**CITY OF ALBUQUERQUE  
PLANNING DEPARTMENT  
November 6, 2013  
DRB Comments**

**ITEM # 7**

**PROJECT # 1006520**

**RE: Hope Plaza**

PLAT OF
LOTS 1 THRU 6
HOPE PLAZA
 (BEING A REPLAT OF TRACT B-1-B, HOPE PLAZA)
 SITUATE WITHIN
THE ELENA GALLEGOS GRANT
 IN
PROJECTED SECTION 17, TOWNSHIP 11 NORTH, RANGE 4 EAST
NEW MEXICO PRINCIPAL MERIDIAN
CITY OF ALBUQUERQUE
BERNALILLO COUNTY, NEW MEXICO
 APRIL, 2014

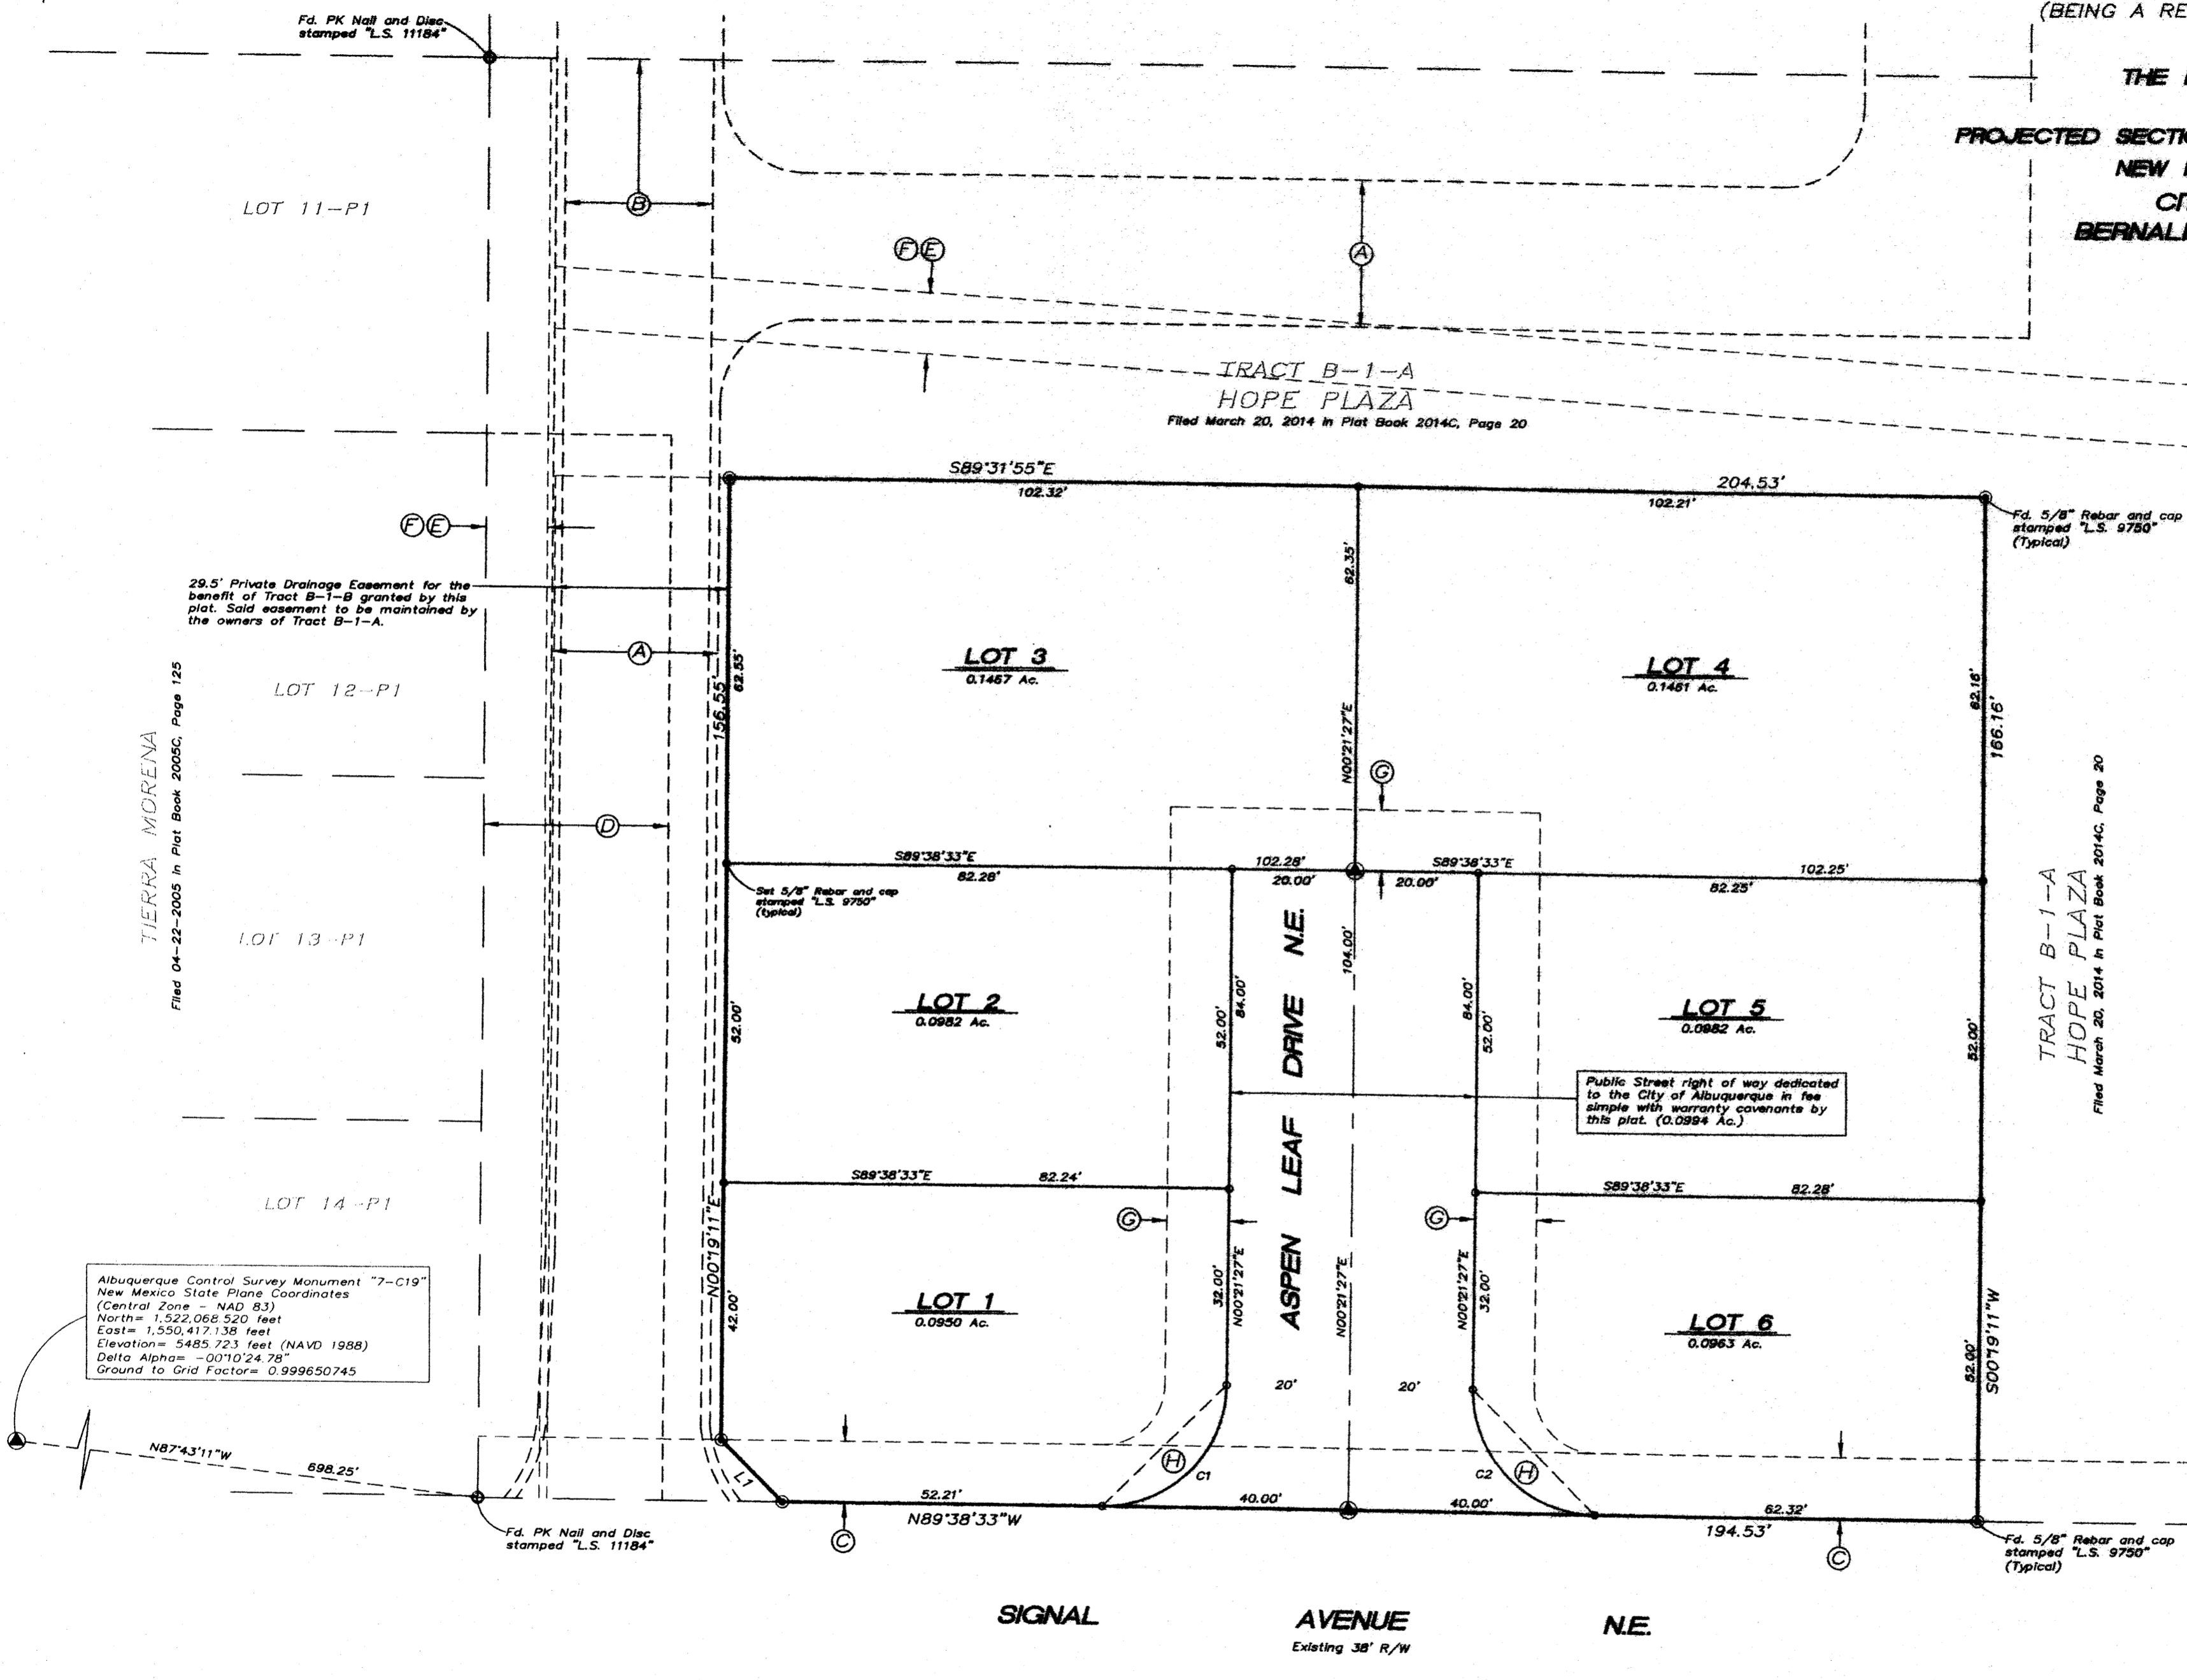
Per the Subdivision Ordinance, platting for this site must conform to an approved site development plan; the proposed lot line appears to conflict with existing parking lot improvements.
